Summary of Natural England's Written Representations advice in respect of A46 Coventry Junctions (Walsgrave)

Drawing Number
HE604820-OIL-EBD-00-DR-LB-30069

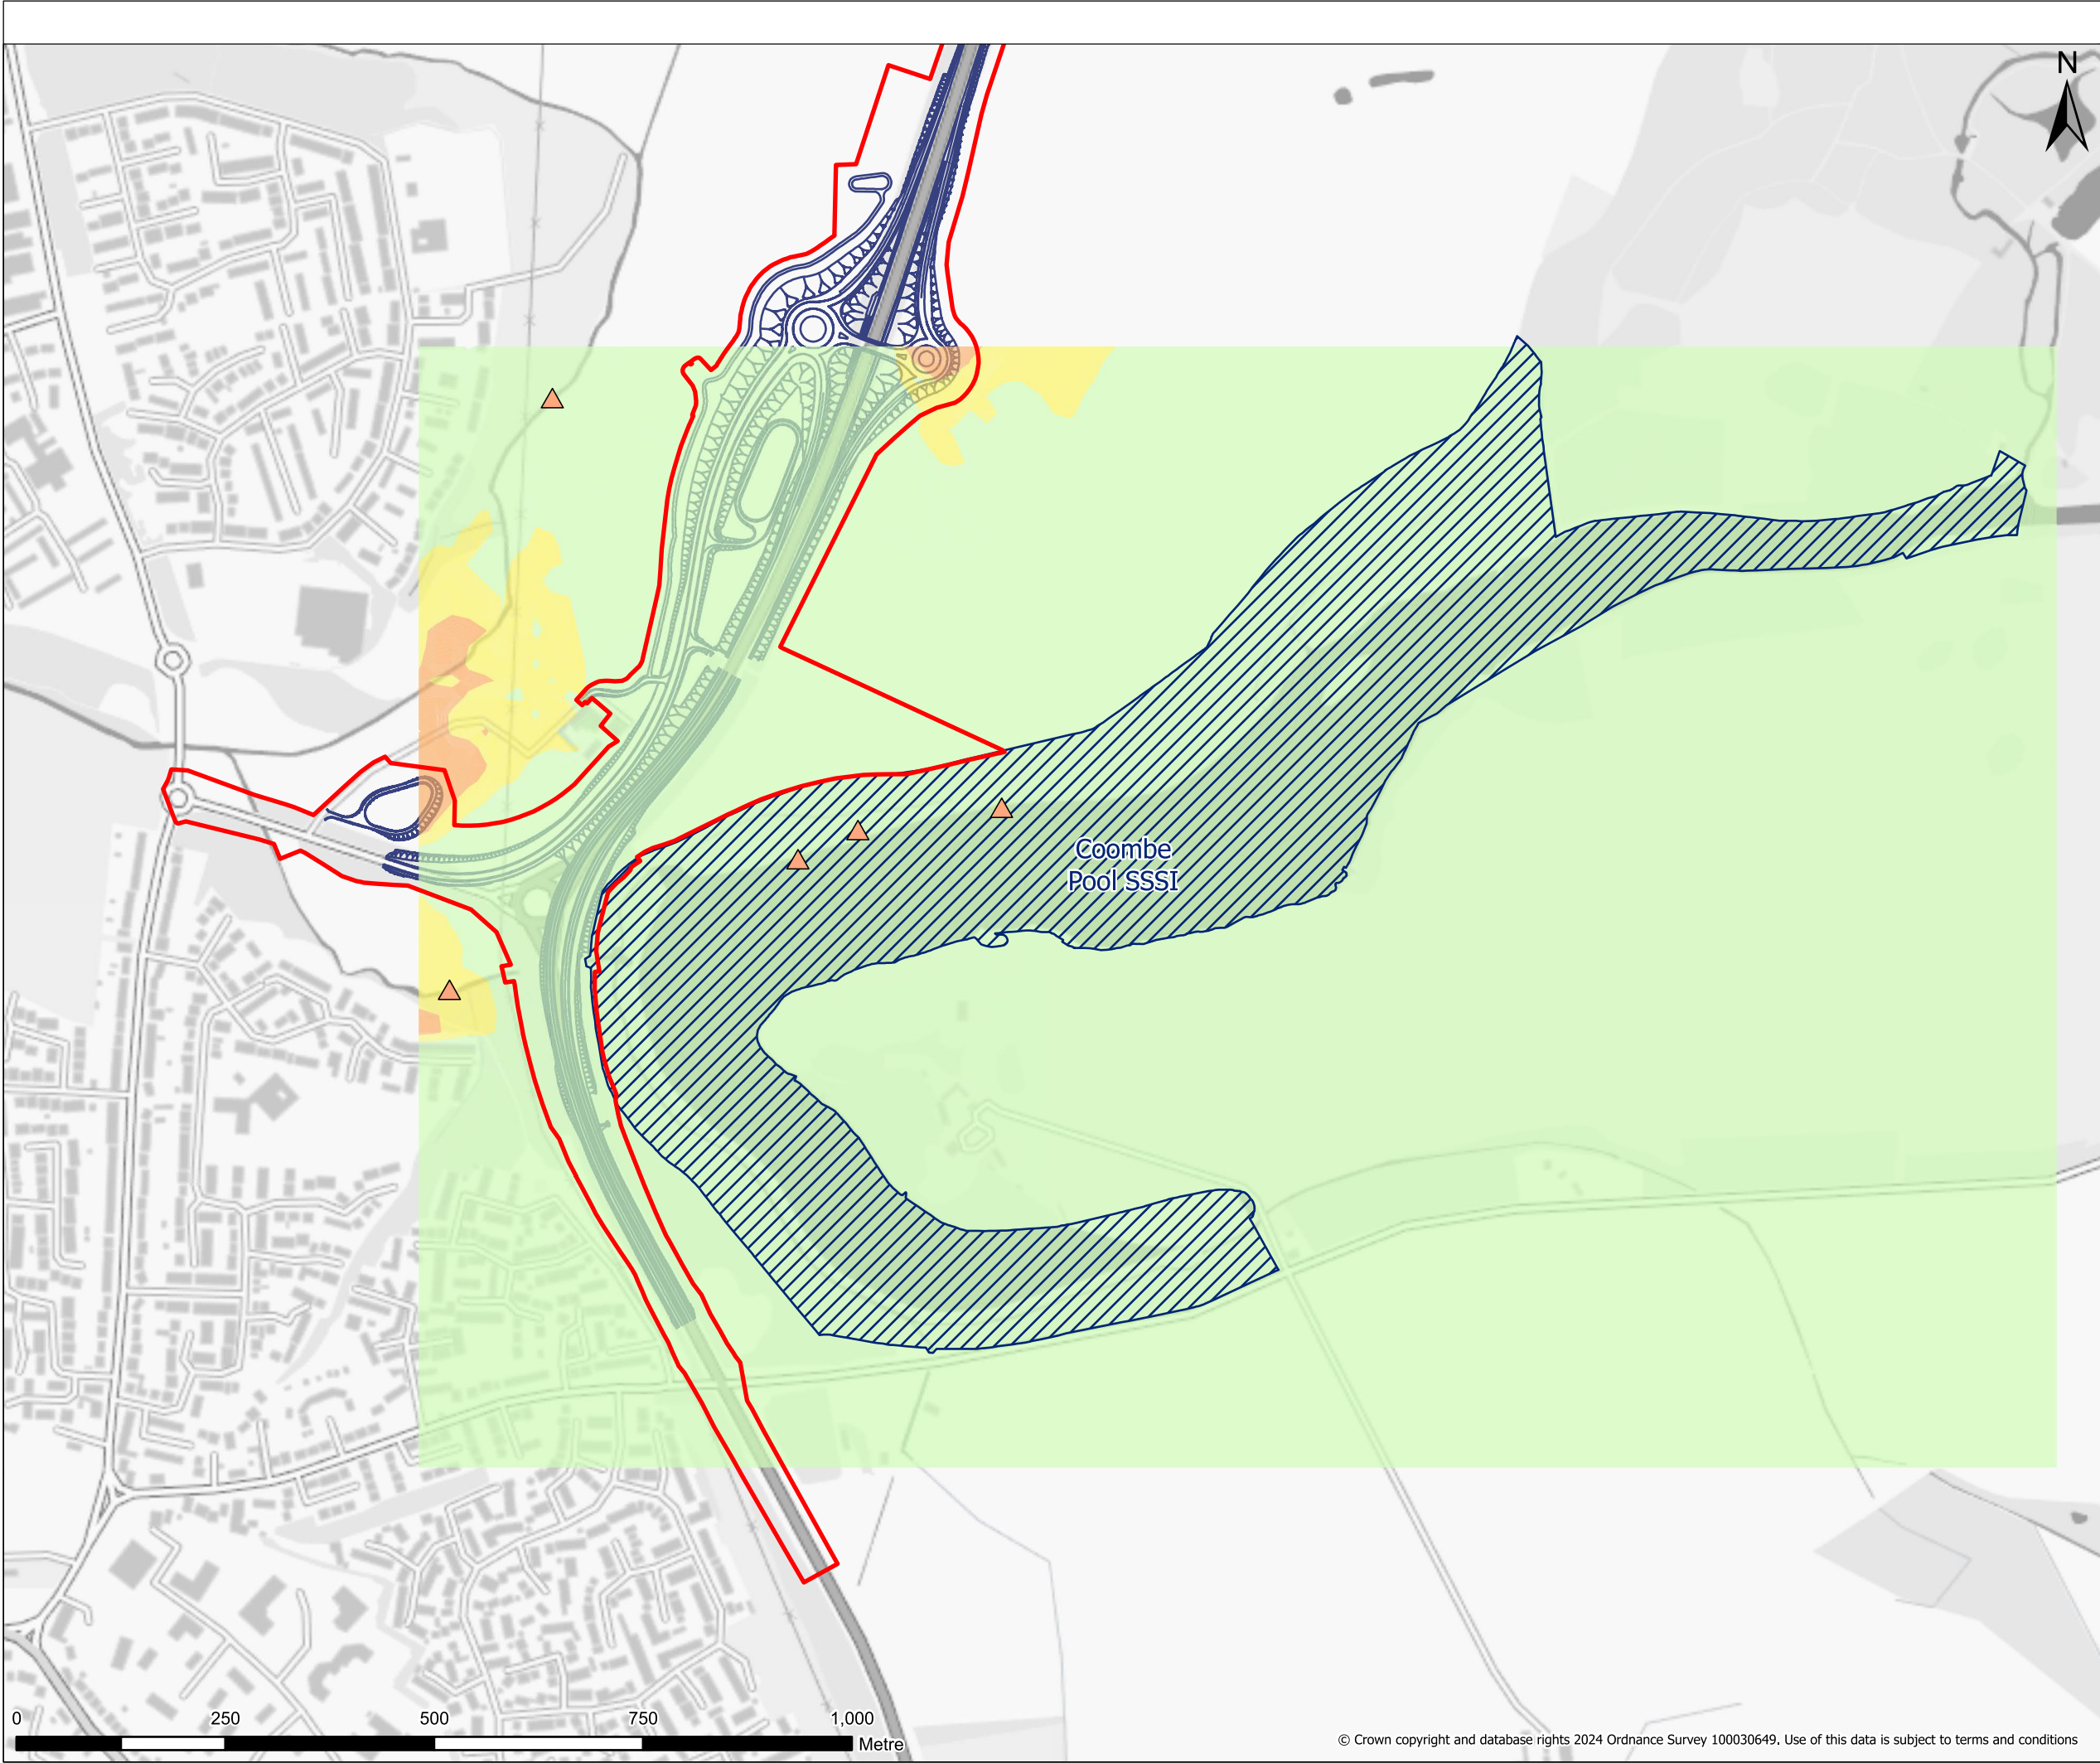
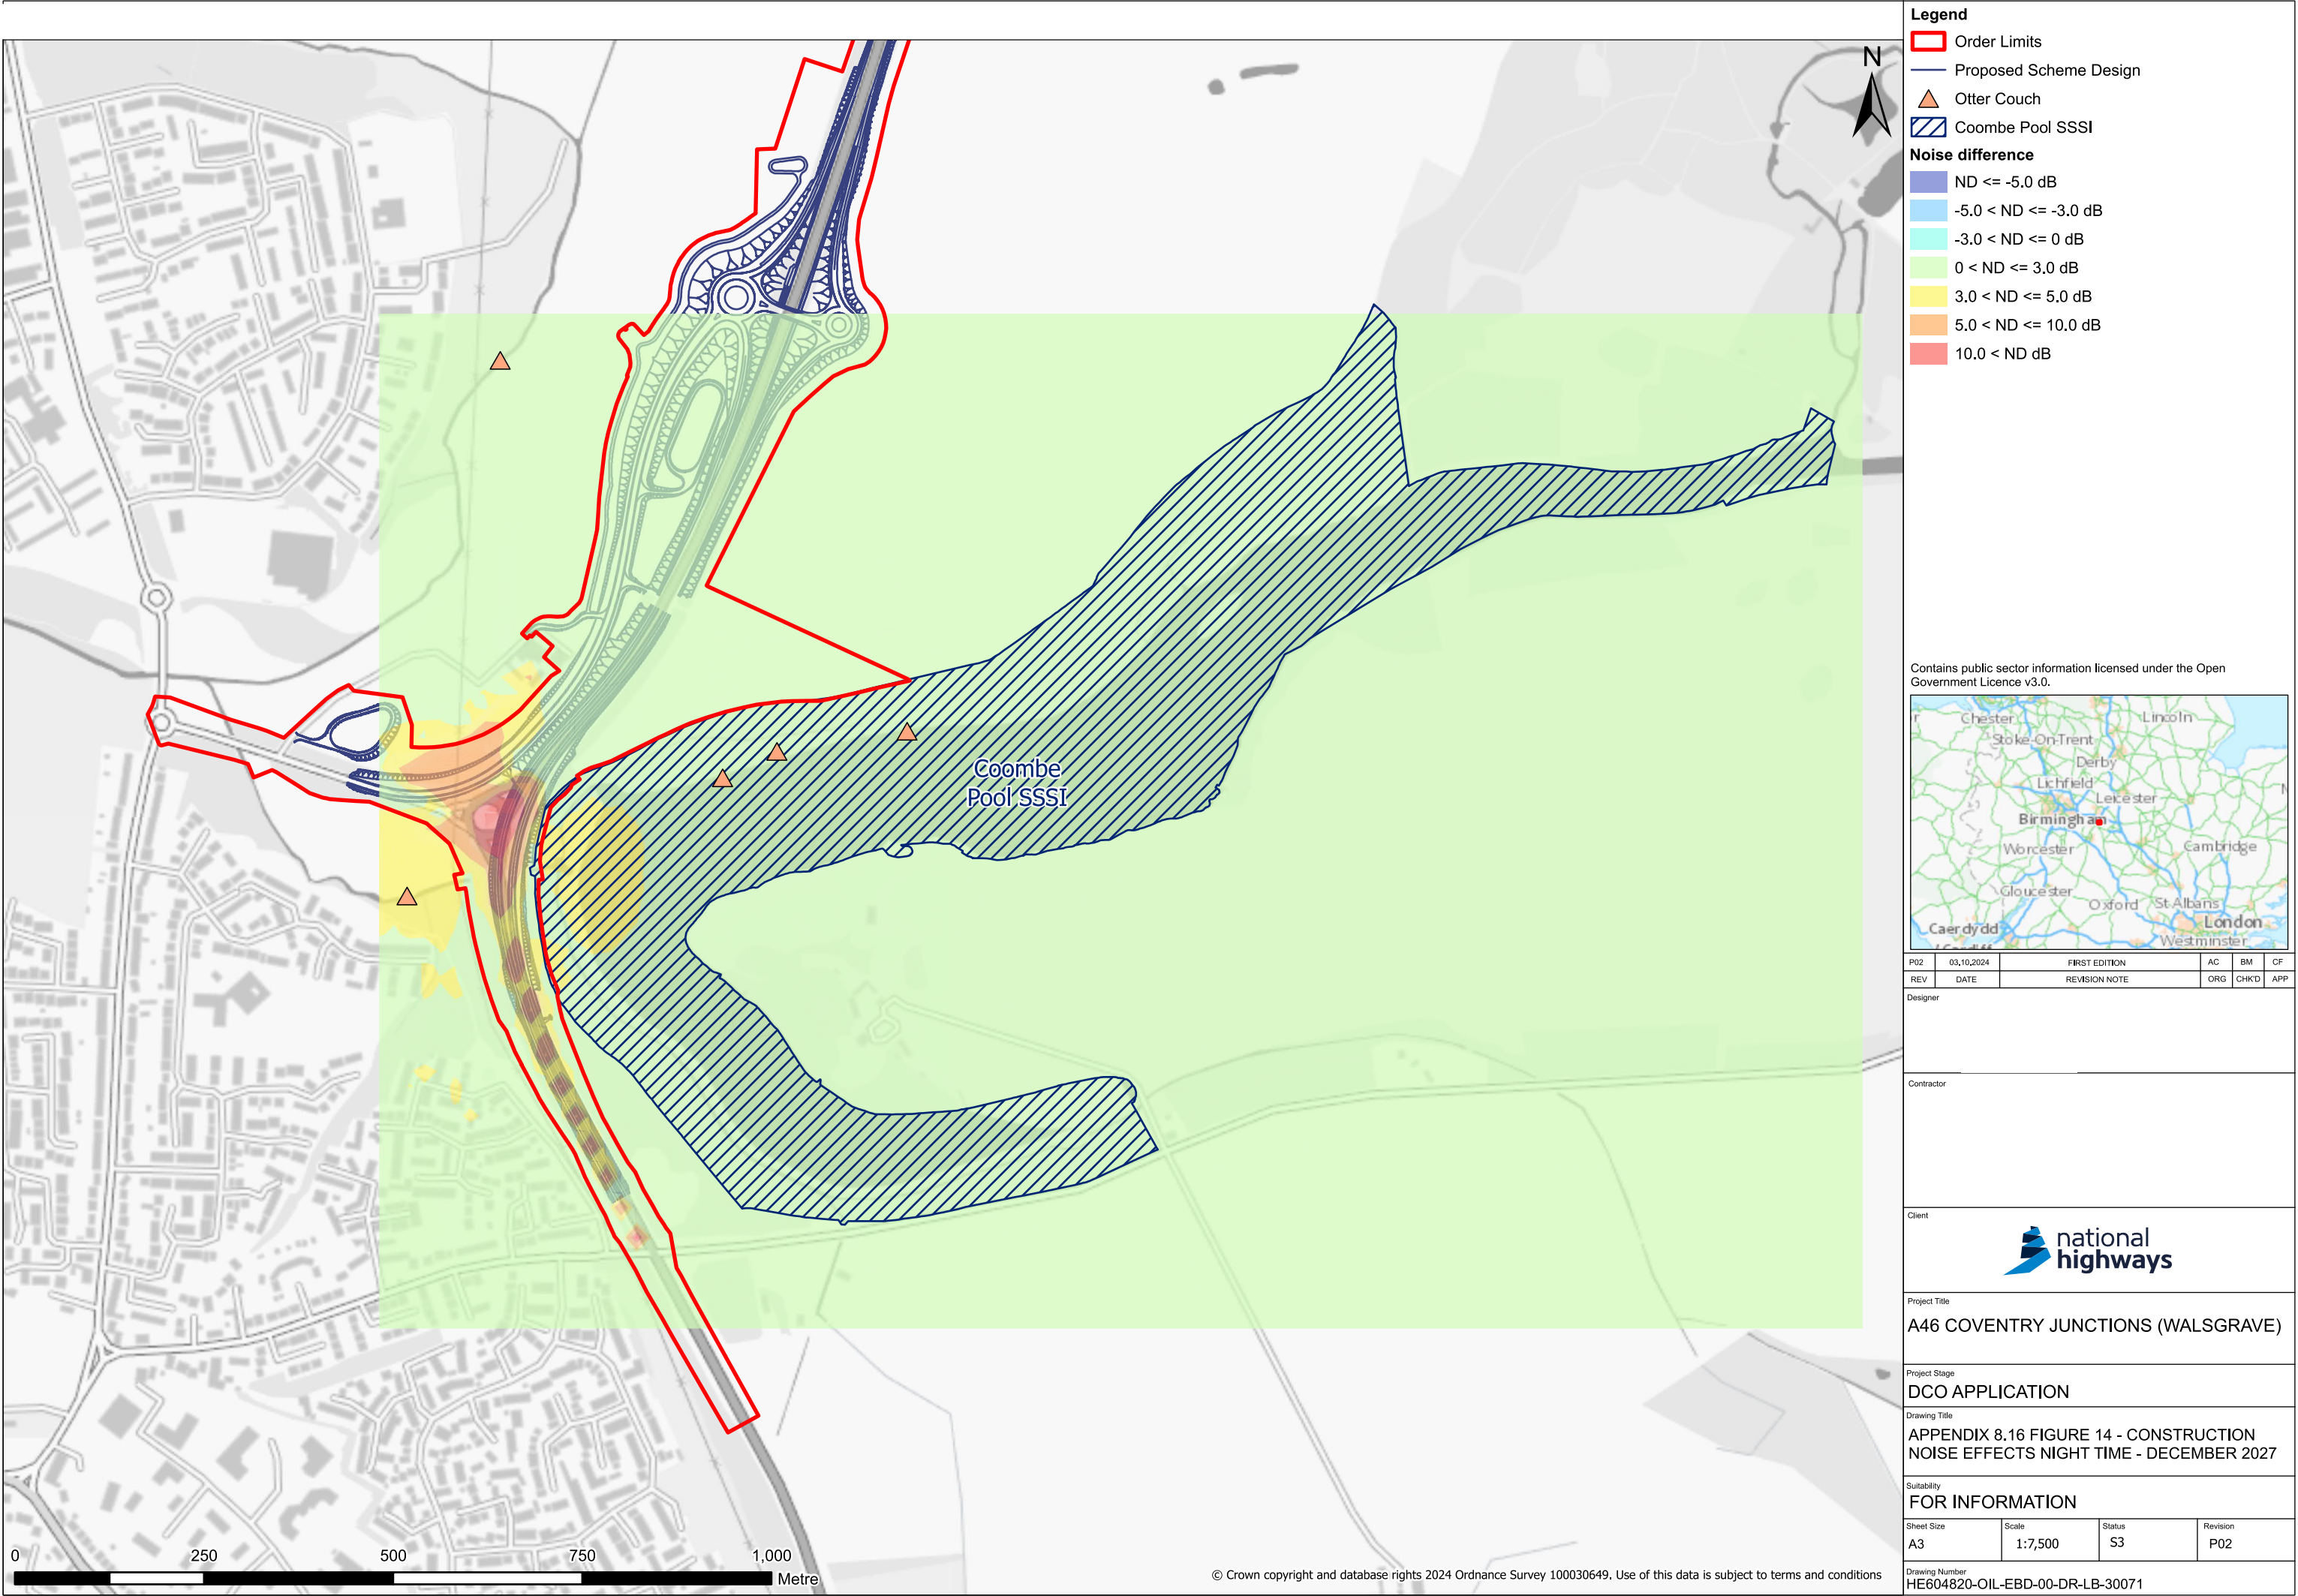
- Impacts of noise and lighting on Combe Pool SSSI and mitigation to prevent impacts (NE4).
- Impacts from air quality (NOx, NH3, N dep) on Combe Pool SSSI and Herald Way Marsh SSSI (NE6).
- Impacts on water quality and water quantity on Combe Pool SSSI and Herald Way Marsh SSSI (NE7).
